**Subject: Onejoy Place
Revised Plans & Additional Information**

Terradyn Consultants has prepared revised Site Plans and assembled additional information for Onejoy Place resulting from the city's decision to not allow a sidewalk to be constructed on the 157 Brackett Street parcel. The revised plans and documents described below will be uploaded to the city's electronic plan review system as separate documents.

SHEET DESCRIPTION
ONEJOY PLACE
1 JOY PLACE, PORTLAND, MAINE 04102
SITE LAYOUT PLAN

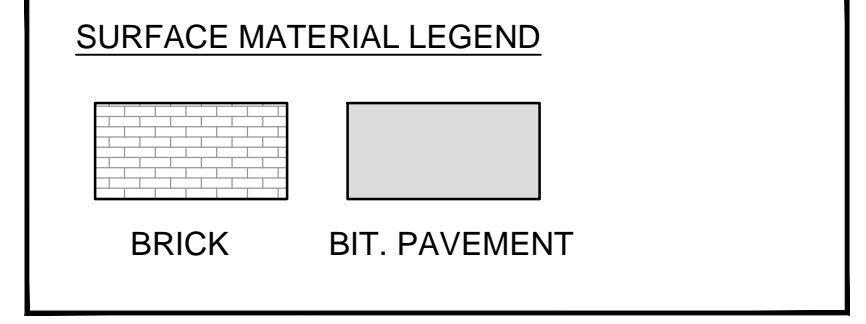
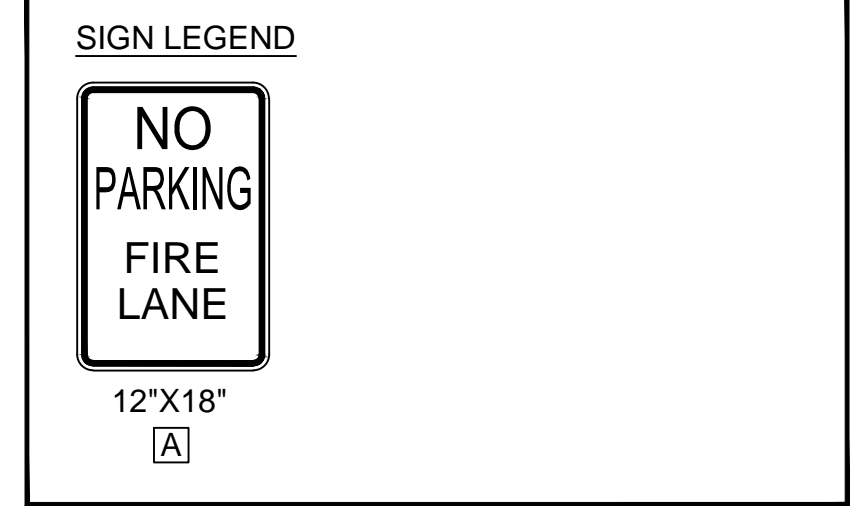
3. The two bike hitches previously proposed to be located at the end of the sidewalk between Joy Place and 157 Brackett Street have been relocated to the north side of the building, in the vicinity of the solid waste and kayak storage.

Reference: Plan Sheet C-3.0 Site Layout Plan

**RECORDING PLAT**  
AT  
1 JOY PLACE, PORTLAND, MAINE  
MADE FOR OWNER OF RECORD:  
**ONEJOY PLACE LLC**  
TWO UNION STREET, 5TH FLOOR  
PORTLAND, MAINE 04101

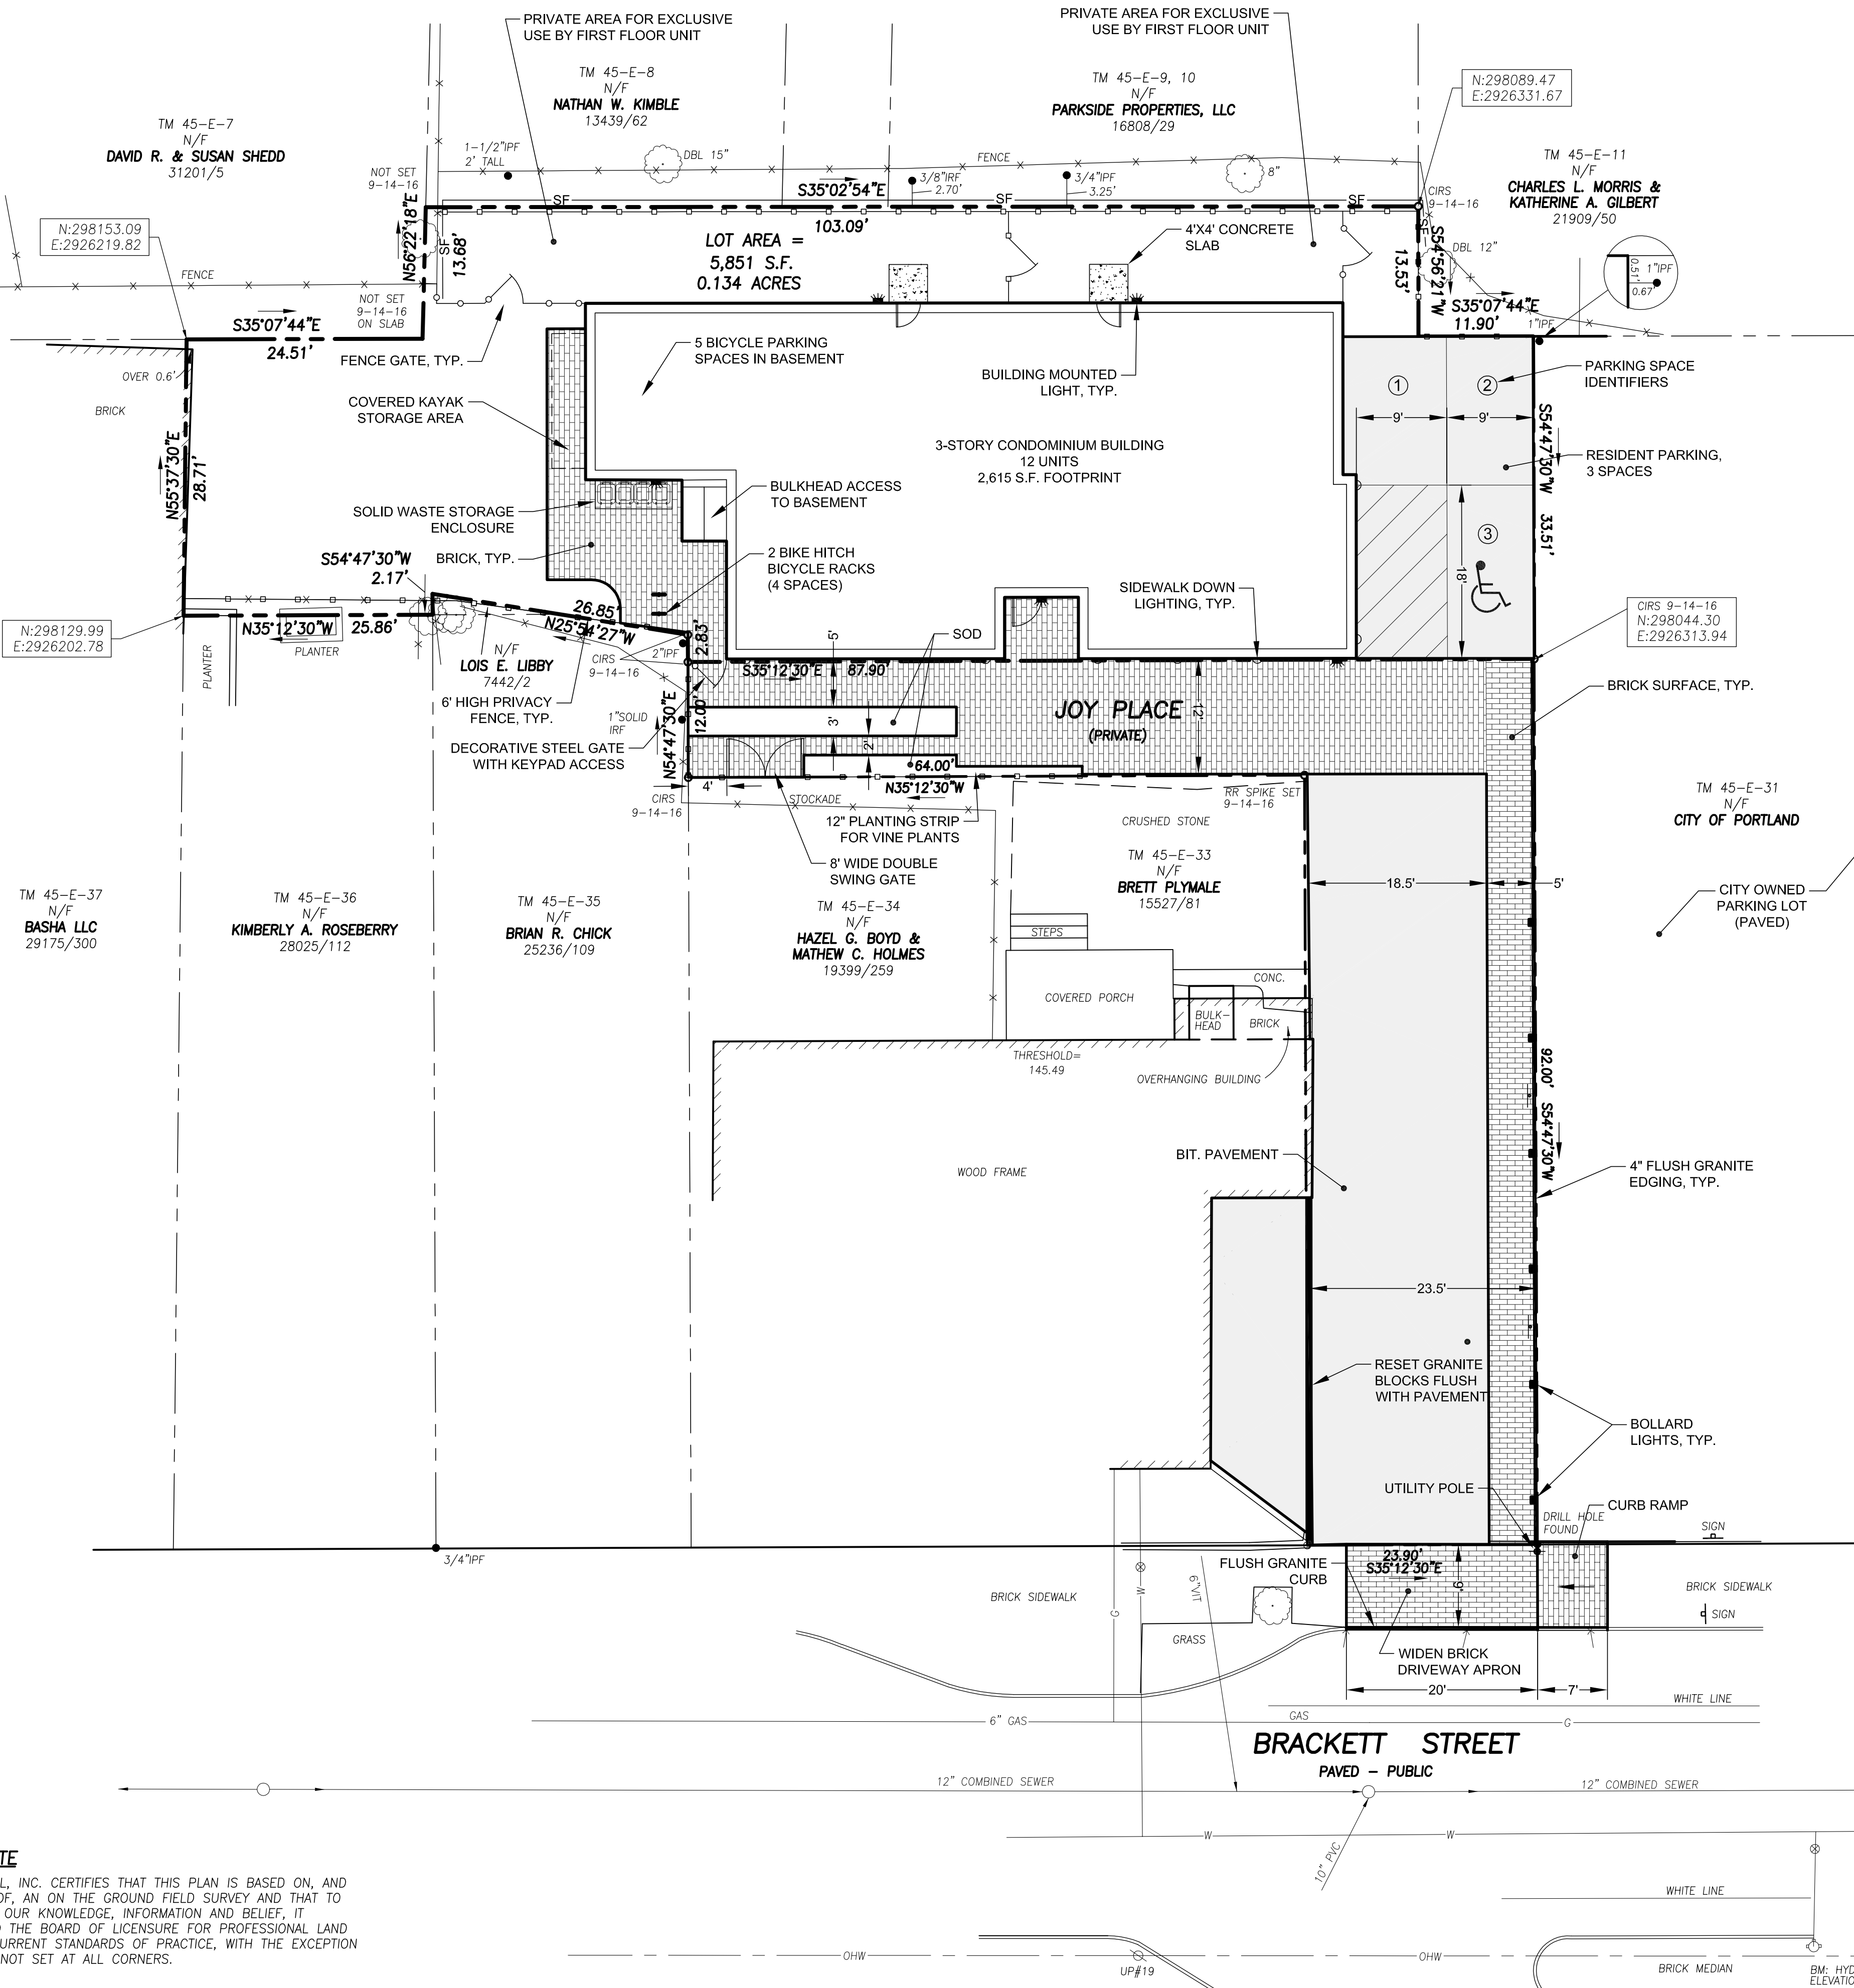
5. A draft Recording Plat has been prepared by Owen Haskell, Inc., the project surveyor. Owen Haskell is in the process of revising the plat to reflect the revisions described above. The revised plat will be uploaded to the e-plan system when it is available.
